EL PASO COUNTY GRADING AND EROSION CONTROL PLAN CHECKLIST

EPC Project Number:

Revised: October 2021

File: O:\18004A-Crossroads MU-Retail\Equity Group\Dwg\Const Dwg\Grading\GR03.dwg Plotstamp: 8/1/2023 11:27 AM

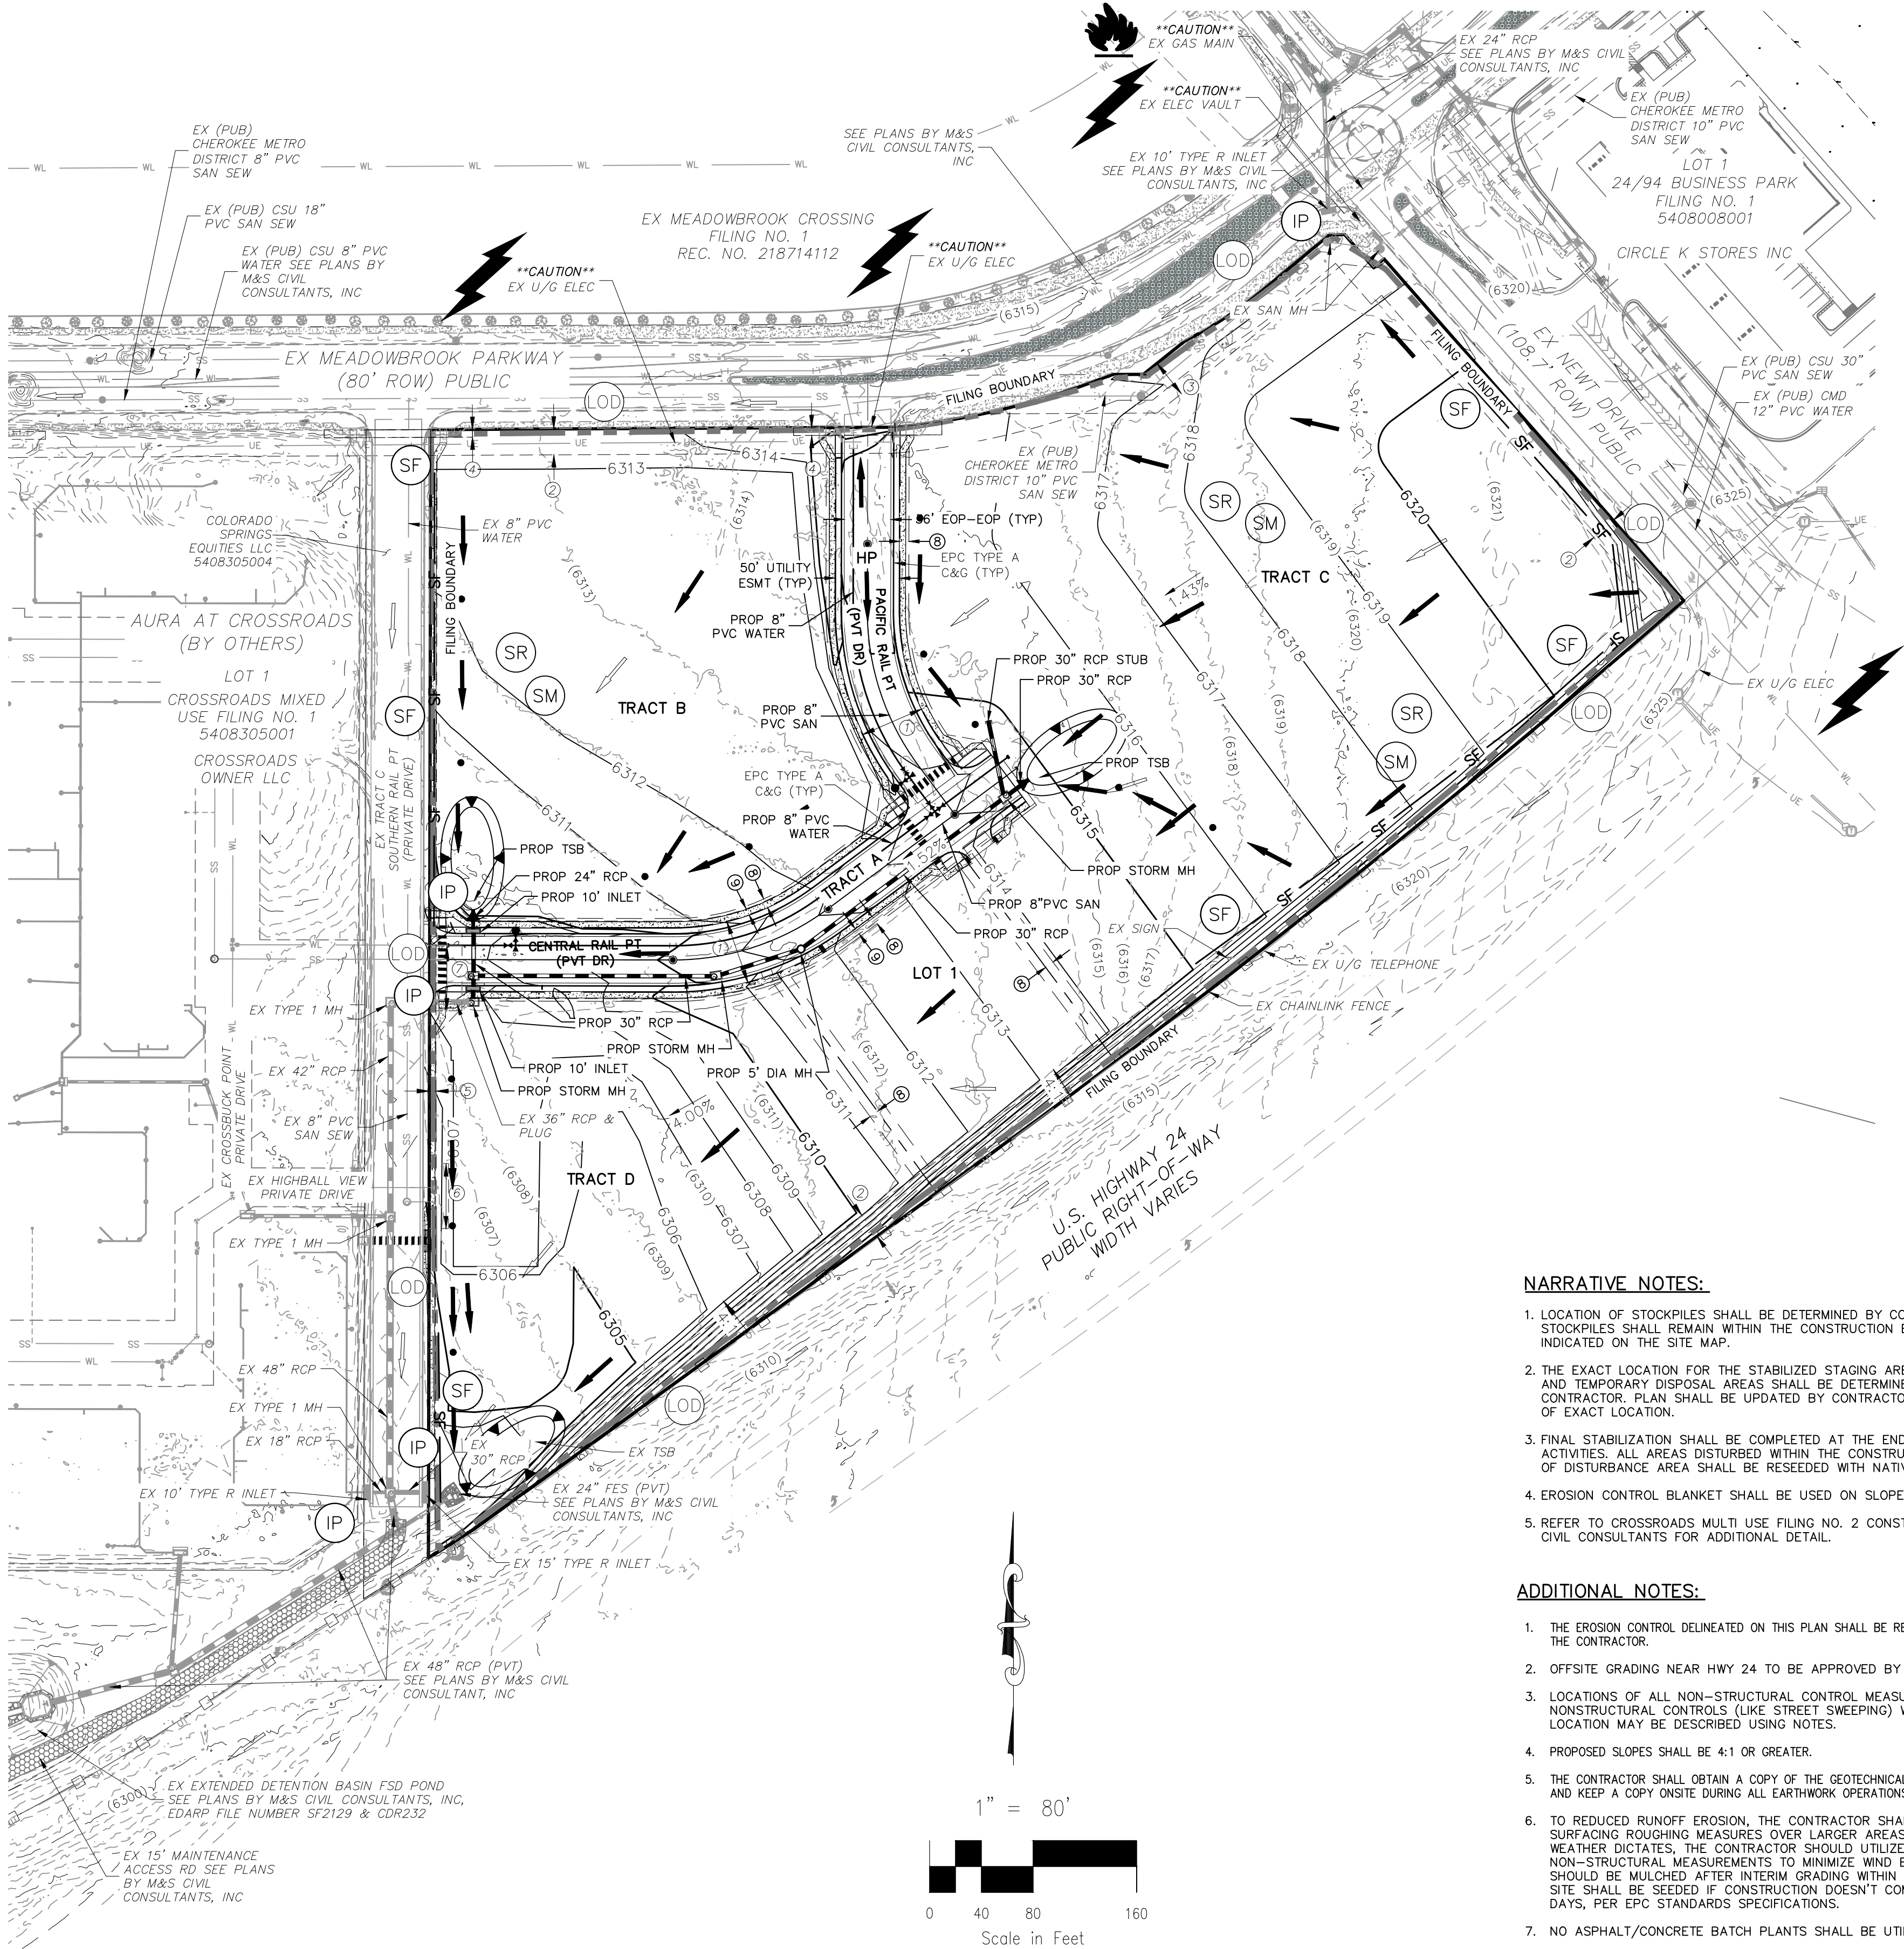
v	All proposed temporary construction control measures, structural and non-structural. Temporary construction control measures shall be identified by phase of implementation to include "initial," "interim," and "final" or shown on separate phased maps identifying each phase		Y
w	Vehicle tracking provided at all construction entrances/exits. Construction fencing, barricades, and/or signage provided at access points not to be used for construction		Y
x	Temporary sediment ponds provided for disturbed drainage areas greater than 1 acre		N

See comment on sheet GR03
